Response to Section 51 advice for Thanet Extension

Thanet Extension Offshore Wind Farm

Appendix 1 to Response to Section 51 Advice:
Section 44 consultees

## Land Plan (Onshore) - Sheet 2

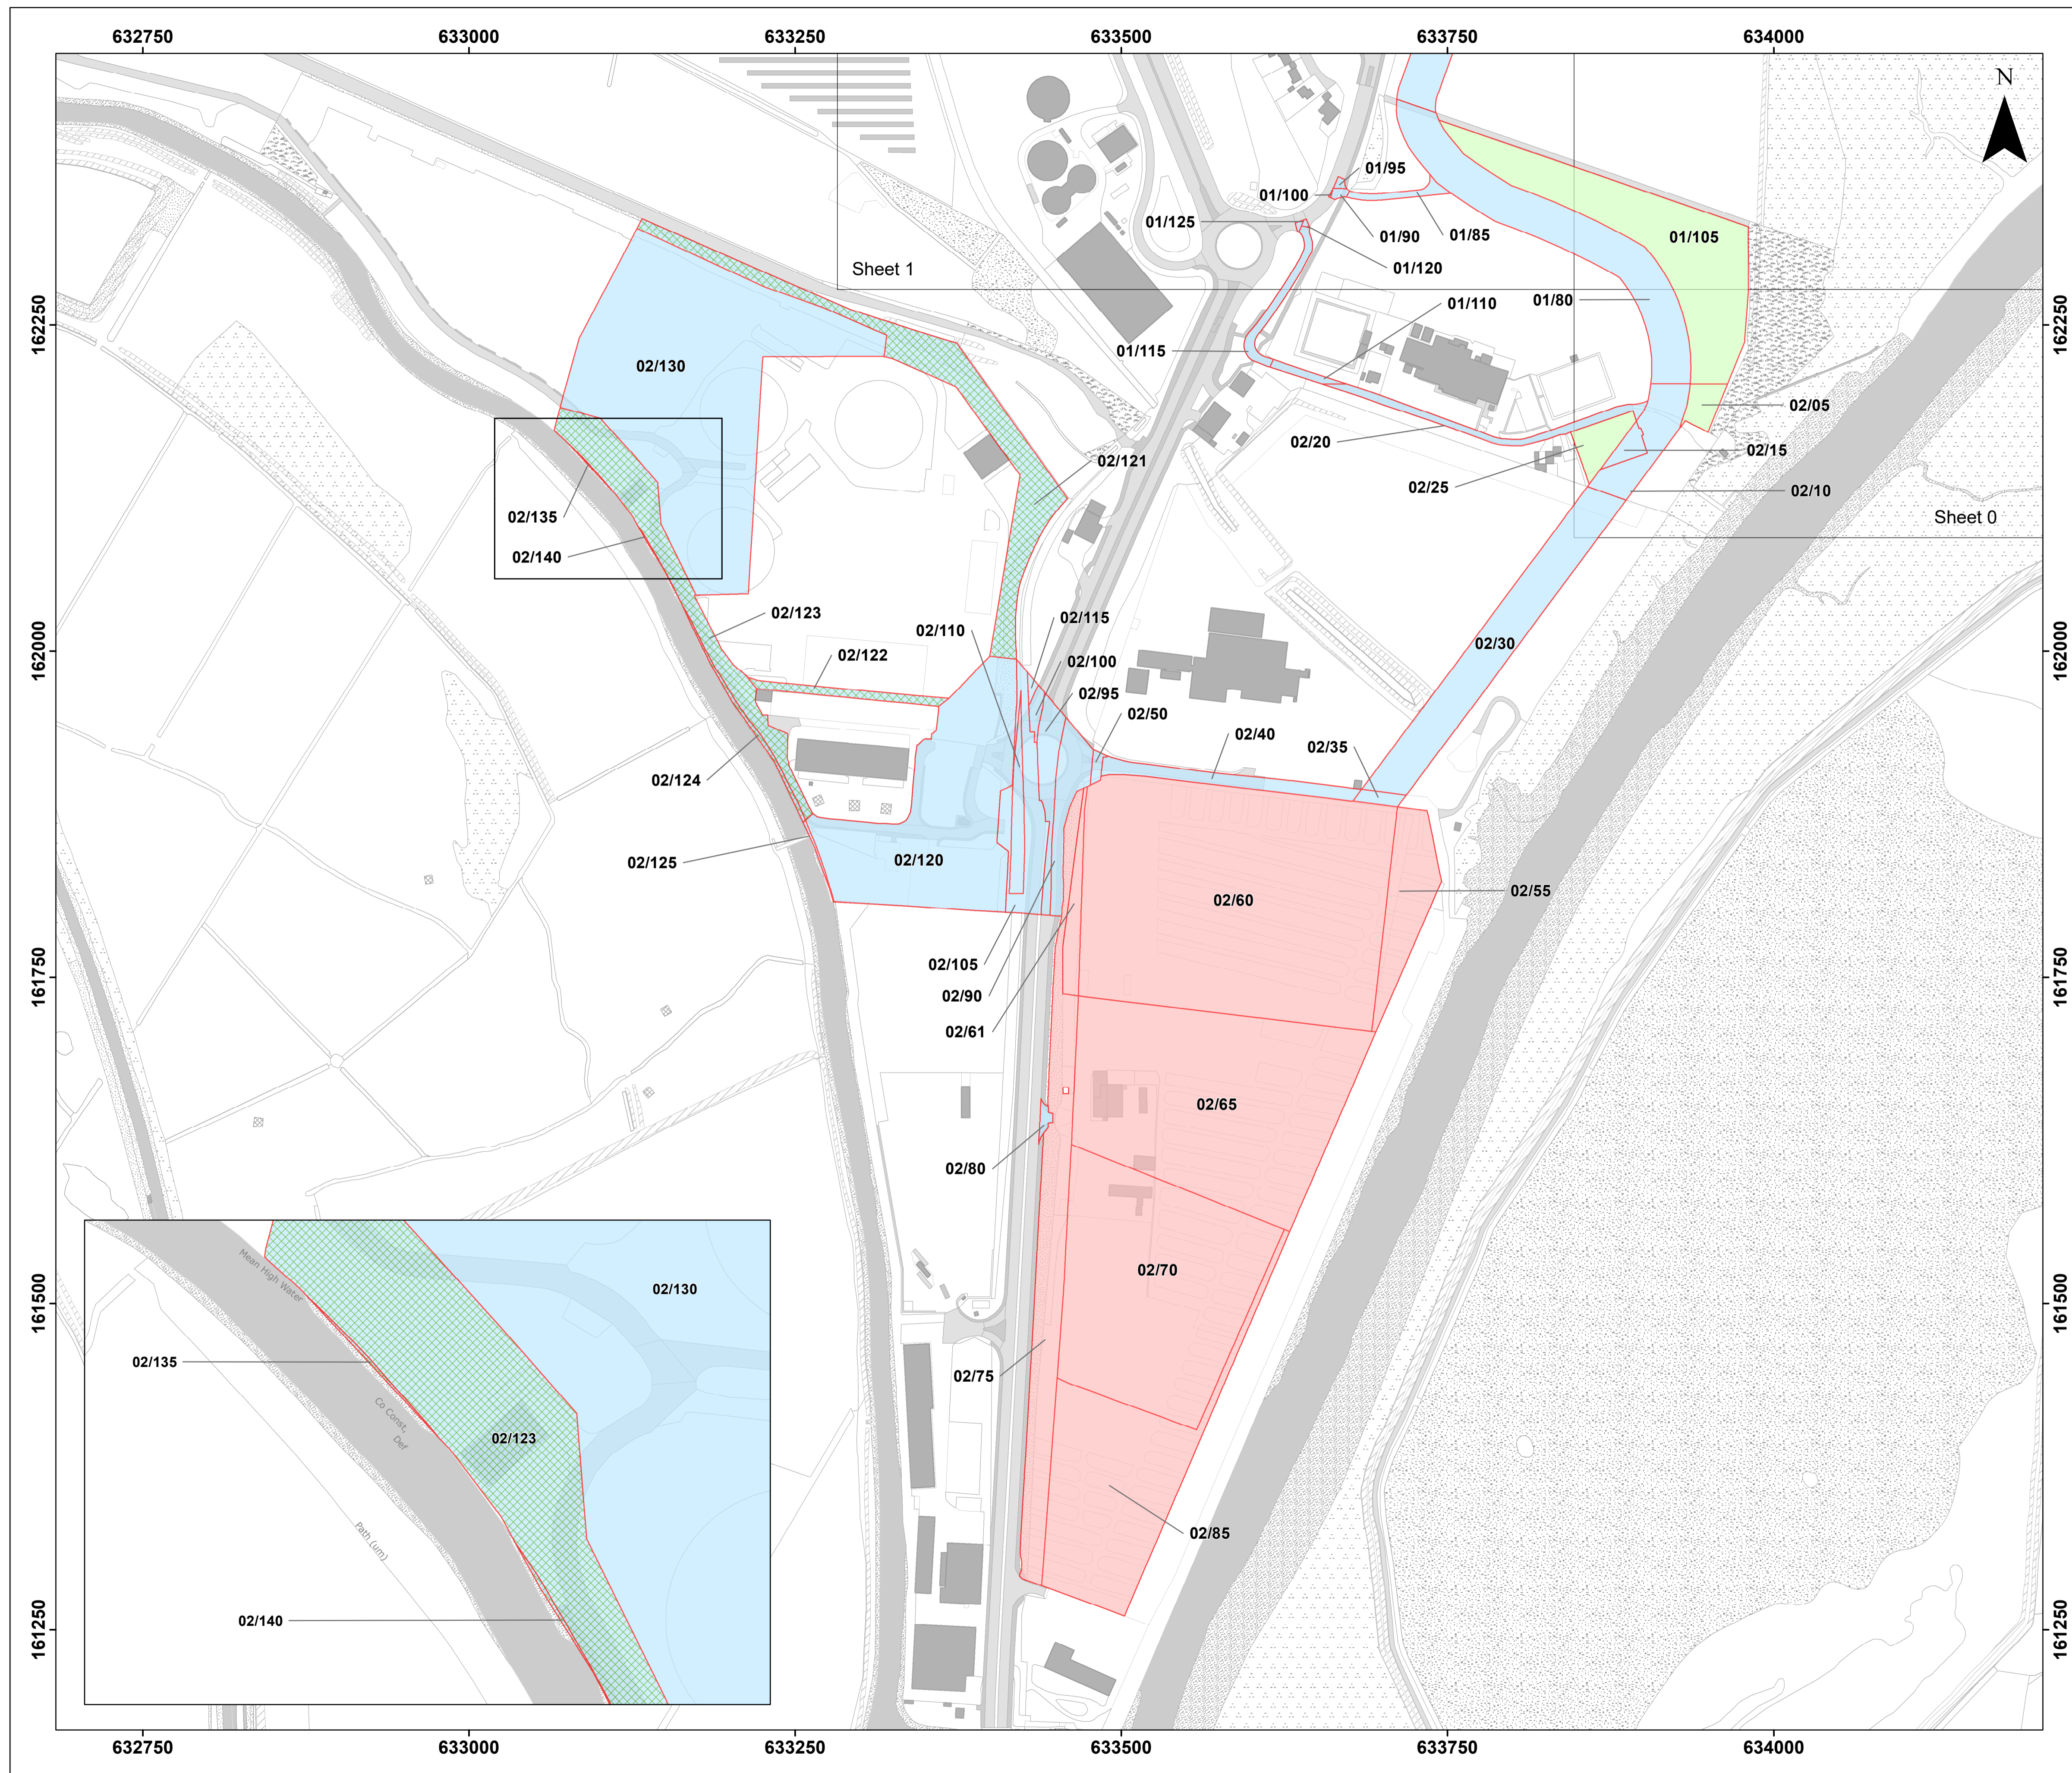
PINS comment in Section 51 letter	Applicant's response
<p>Please provide updated Land Plans that can be read which include:</p> <p>All relevant landmarks as described in Column 2 ('Description of Land') of the BoR e.g. Pegwell Bay Country Park, Sandwich Road, Ebbsfleet Roundabout and the A256 to be reflected on the relevant Sheets associated to the Land Plans.</p> <p>Insets to assist the reader.</p> <p>All plots on the individual sheets to be provided with the correct plot reference and colour code which is consistent with the other application documents.</p>	<p>This will provided at least 10 days prior to the Preliminary Meeting</p> <p>Landmark descriptions have been added to the OS mapping for clarity.</p> <p>Insets where requested have been added.</p> <p>This has been updated as per PINS' specific comments below.</p>
PINS comment in Section 55 checklist	Applicant's response
<p>The legend on the plans identifies blue coloured plots as 'Permanent acquisition of new rights'. Should this be 'Creation of new rights' or 'Extinguishment of rights'?</p> <p>Plot 01/35 could benefit from an inset as it is unclear whether this plot is coloured green or blue. The Book of Reference refers to temporary rights and the plot is included in Schedule 7 of the DCO (Land of which Temporary Possession may be taken). However the plot is also included in Schedule 5 (Land in which only New Rights etc., may be acquired).</p>	<p>The Applicant has reviewed this wording and the description used in other applications and is content that this accurately describes the approach taken.</p> <p>An inset has been added for Plot 01/35.</p> <p>Plot 01/35 is correctly scheduled for both temporary possession and the acquisition of permanent new rights, in keeping with the Applicant's strategy for the majority of the plots within the Order Limits.</p> <p>The Book of Reference has been updated to reference both rights of temporary possession and new rights; a revised Book of Reference will be submitted at Deadline 1.</p>

Plot 01/50 is coloured green on the land plan, showing it is temporary possession and is included in Schedule 7 of the DCO (Land of which Temporary Possession may be taken) and not in Schedule 5 (Land in which only New Rights etc., may be acquired). However the Book of Reference refers to new rights.	The Book of Reference has been updated to reference both rights of temporary possession and new rights; a revised Book of Reference will be submitted at Deadline 1.
Plot 01/55 is coloured green on the land plan, showing it is temporary possession and is included in Schedule 7 of the DCO (Land of which Temporary Possession may be taken) and not in Schedule 5 (Land in which only New Rights etc., may be acquired). However the Book of Reference refers to new rights.	The Book of Reference has been updated to reference both rights of temporary possession and new rights; a revised Book of Reference will be submitted at Deadline 1.

Plot 01/105 is coloured green on the land plan, showing it is temporary possession and is included in Schedule 7 of the DCO (Land of which Temporary Possession may be taken) and not in Schedule 5 (Land in which only New Rights etc., may be acquired). However the Book of Reference refers to new rights.	The Book of Reference has been updated to reference both rights of temporary possession and new rights; a revised Book of Reference will be submitted at Deadline 1.
The area containing plot 01/100 on sheet 1 of the Land Plan Onshore could benefit from an inset.	An inset has been added for Plot 01/100.
Plots 01/80 and 01/115 are not identified on sheet 1 of the Land Plan Onshore.	This issue has been addressed by amending the cut lines to ensure these plots are properly identified.
Plot 01/110 is only identified on sheet 2 of the Land Plan Onshore. Should this plot be assigned an 02 reference?	This issue has been addressed by amending the cut lines to ensure these plots are properly identified.

Plot 02/05 is coloured green on the land plan, showing it is temporary possession and is included in Schedule 7 of the DCO (Land of which Temporary Possession may be taken) and not in Schedule 5 (Land in which only New Rights etc., may be acquired). However the Book of Reference refers to new rights.	The Book of Reference has been updated to reference both rights of temporary possession and new rights; a revised Book of Reference will be submitted at Deadline 1.
Plot 02/85 is identified on the land plan as permanent acquisition but in the Book of Reference as new rights. This plot is not identified in the schedule 5 of the DCO (Land in which only New Rights etc., may be acquired).	This Plot is correctly shaded pink for freehold acquisition on the Land Plans, and accordingly is correctly omitted from schedules 5 and 7 of the DCO. The Book of Reference has been updated to reflect the DCO and will be submitted for Deadline 1.

In the legend 'Cable route options' does not describe what rights are being sought.	The legend has been amended to read 'Cable route options – Permanent acquisition of new rights'.
No landmarks or road names are identified on the land plans	This has been updated on Land Plans and specific land mark names, where needed, have been added to the OS mapping.
The scale is not in compliance with Regulation 5(4A) of the APFP Regulations, for the onshore plan sheet 0.	This sheet has been changed to 1:2,500.
